**GALLOWAY RESPONSE TO COMMENTS  
 IN BLUE BOXES WITH WHITE TEXT**

**EL PASO COUNTY  
 GRADING AND EROSION CONTROL PLAN CHECKLIST**

SF2223

**GRADING & EROSION
CONTROL INTERIM PLAN**

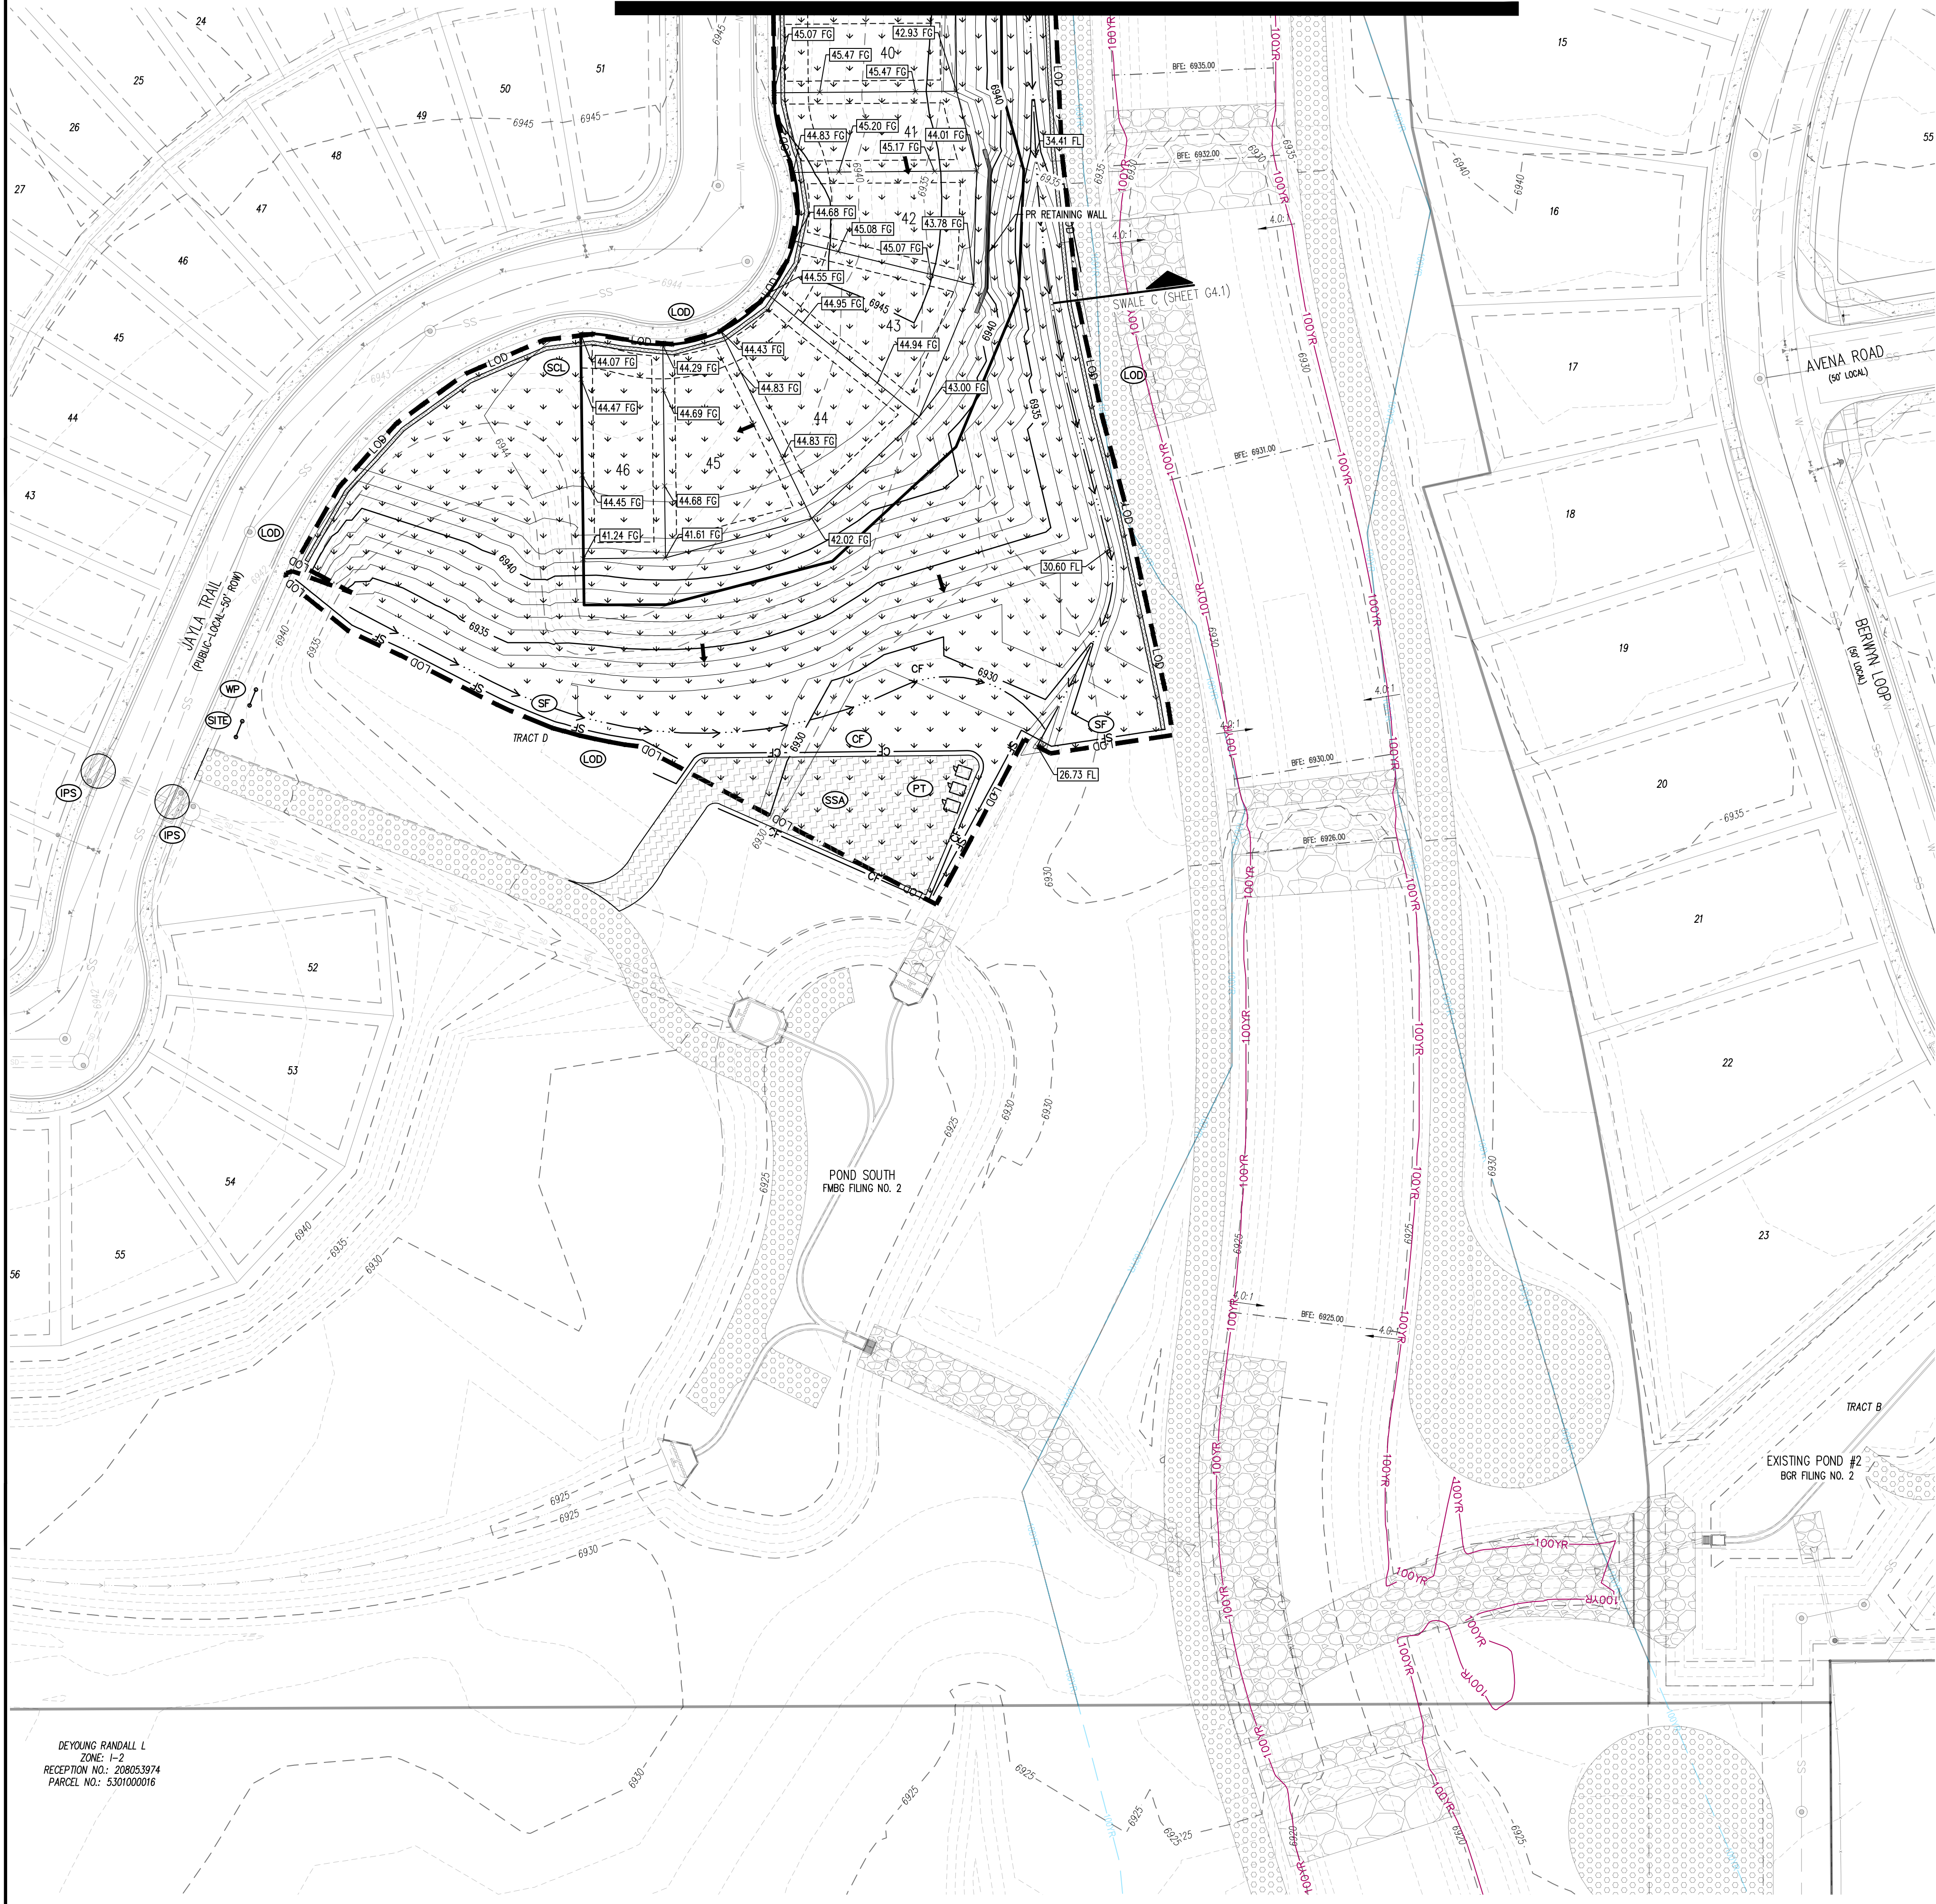
w	Vehicle tracking provided at all construction entrances/exits. Construction fencing, barricades, and/or signage provided at access points not to be used for construction		Y
x	Temporary sediment ponds provided for disturbed drainage areas greater than 1 acre		N

**SWALE AND CHECK DAMS WERE ADDED IN INTERIM PHASE FOR DRAINAGE AS AREA IS < 1 ACRE**
